BRADLEY POINT FILING NO. 1

GRADING/EROSION CONTROL PLANS

APRIL 2023

EL PASO COUNTY FILE NO. MS-21-002

GRADING AND EROSION CONTROL PLAN

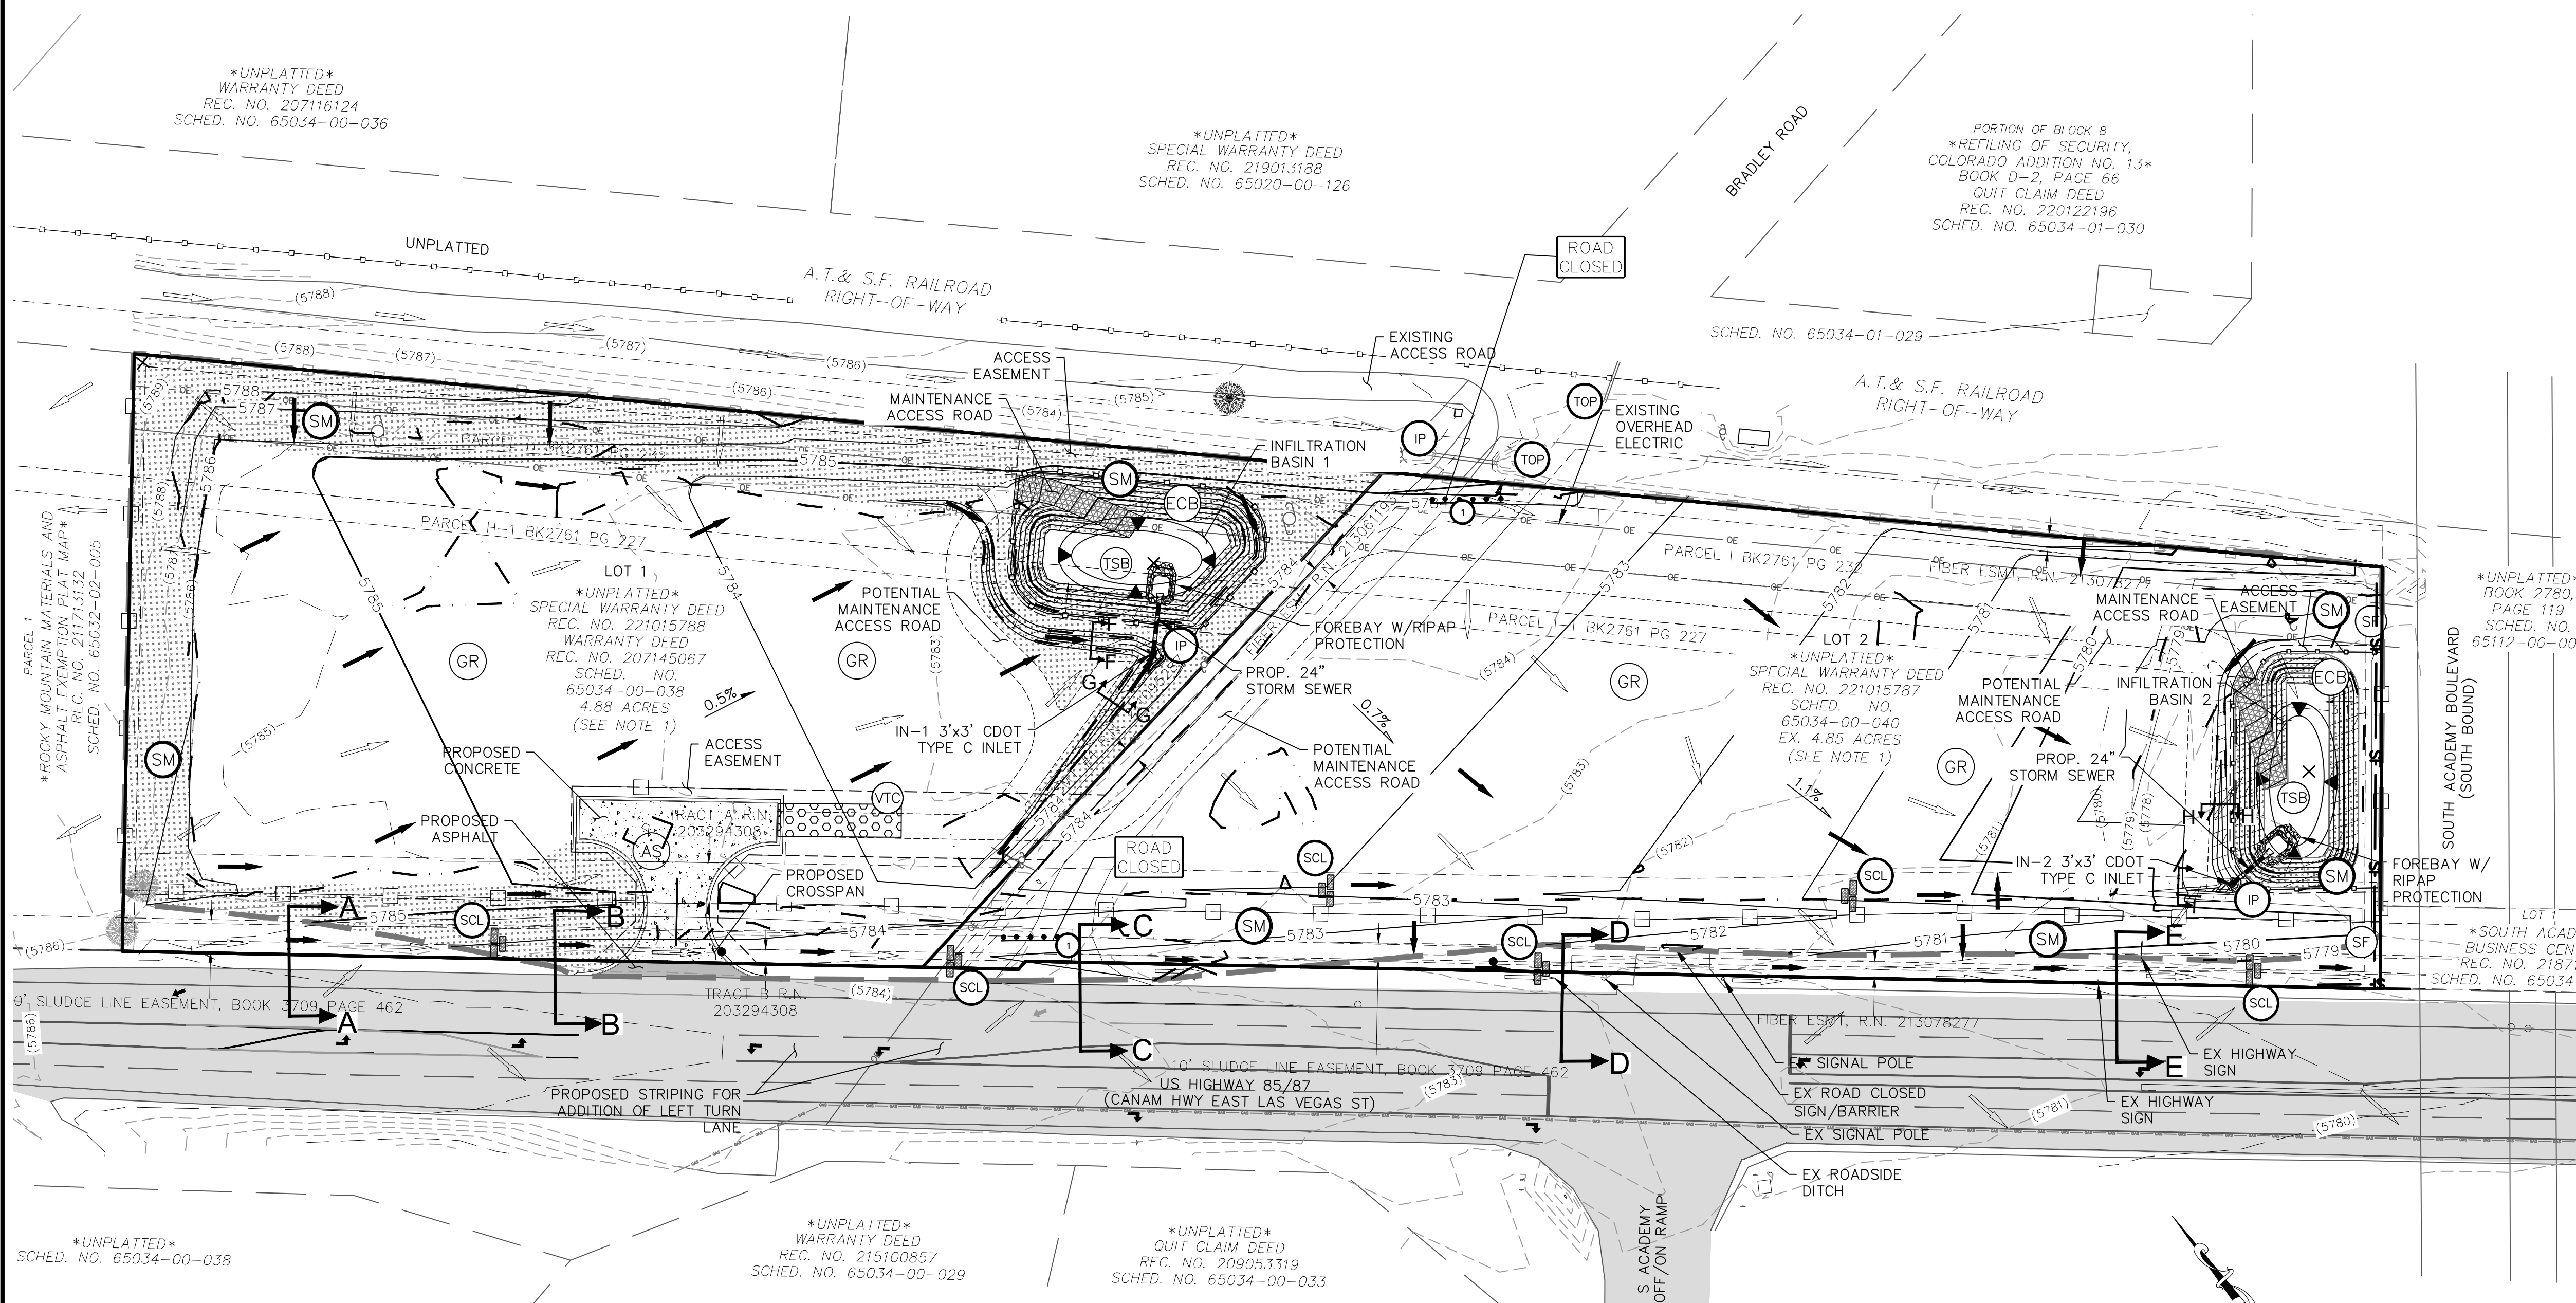
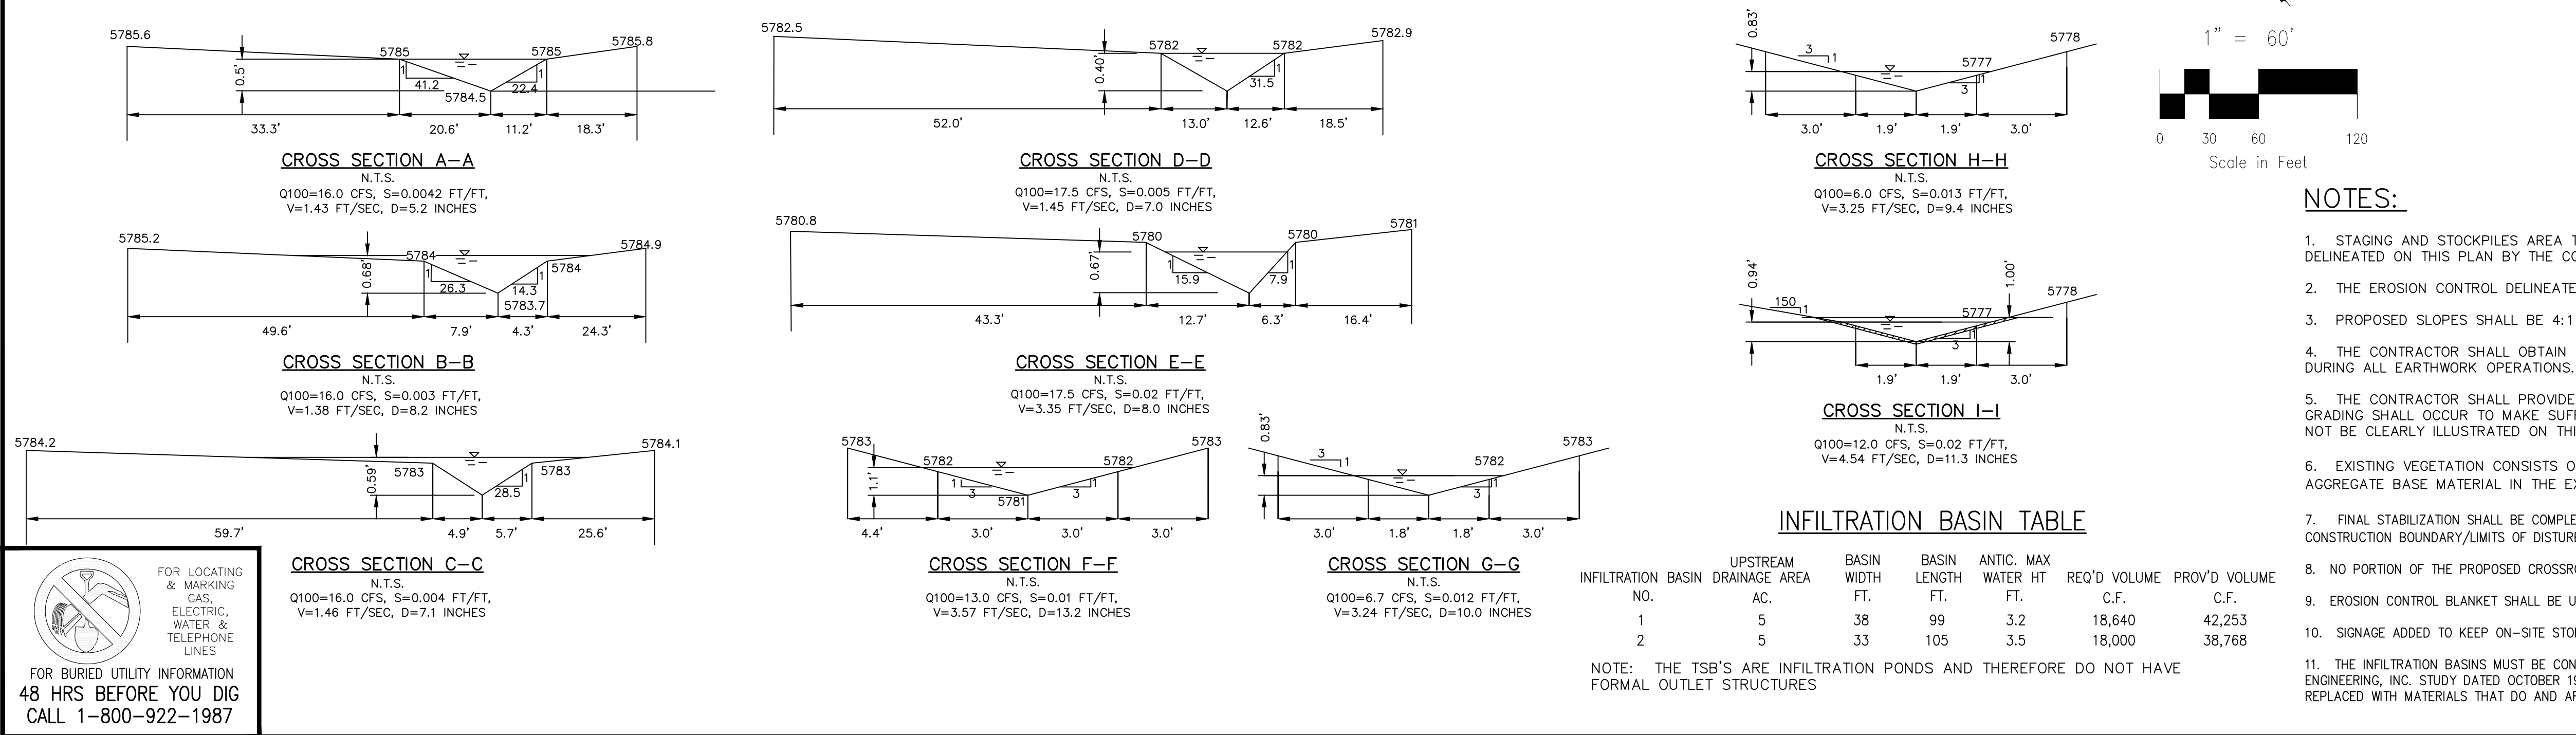
Unresolved from Submittal 3: provide basin details (forebay riprap dimensions and size)

Add specifications for basins in the notes. The basin require excavation to a depth that has sands/gravels according to the Entech report. Clearly state the required min depth and provide an alt design if the necessary infiltration cannot be achieved by the native soils.

Comment generated due to changes from submittal 3: Provide outlet protection for the outlets. Provide outlet protection detail.

Unresolved from Submittal 3: If "limits of disturbance" and "construction boundary" are the same, change to "limits of construction/disturbance" or otherwise show as separate line types for each on the legend and figure.

Comment generated due to changes from submittal 3: show shapes for seeding, not just labels so it is clear what areas require seeding.
